**From:** [Jordan Bovee](#)  
**To:** [Zach Torrance-Smith](#); [Guy Moura](#); [SEPA@dahp.wa.gov](mailto:SEPA@dahp.wa.gov)  
**Subject:** Re: VA-25-00004 Jones - Notice of Application  
**Date:** Thursday, August 7, 2025 4:35:16 PM

This review is in response to the request for setback variance application: VA-25-00004 Jones

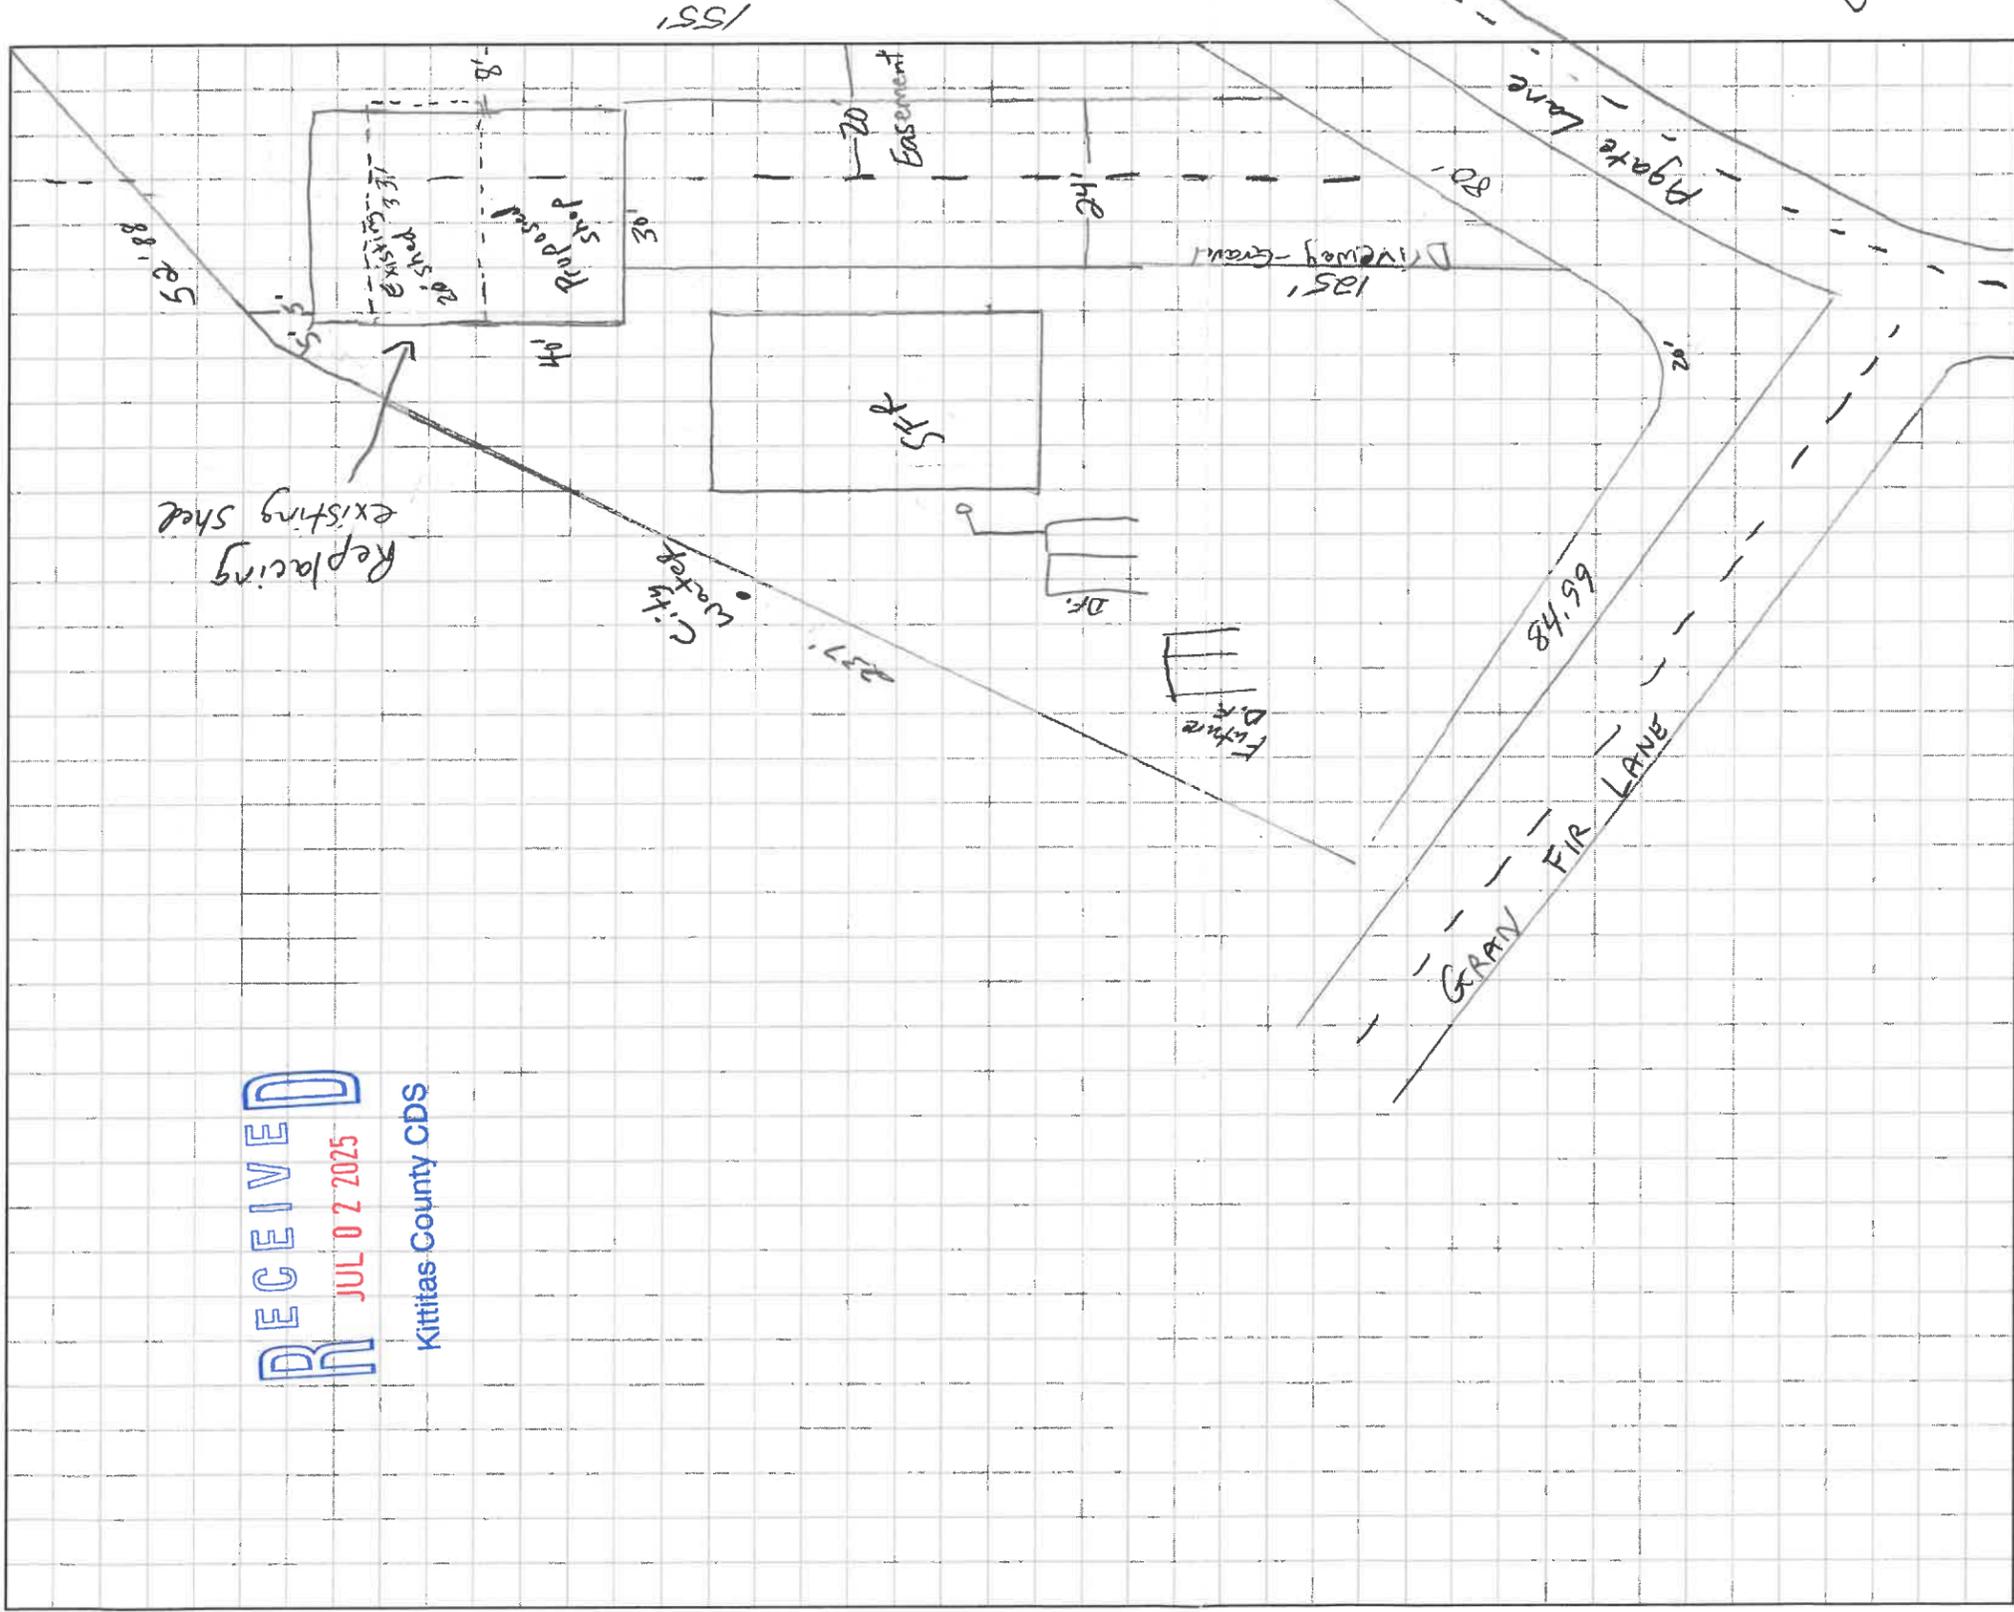
Please be advised that the proposed area for the new shed does fall within the traditional territory of the šnp' əšqwáw səxw (people in between) or Wenatchi, one of the 12 constituent tribes of the Colville Confederated Tribes. This area is also determined by DAHP to have a very high probability for cultural resources to be present and has no record of ever having been subject to a cultural resources survey.

Given the relatively small size of the project and its placement over the existing footprint of the previous shed, the CCT recommends the proponent have on hand an IDP in the event ground disturbance reveals cultural material.
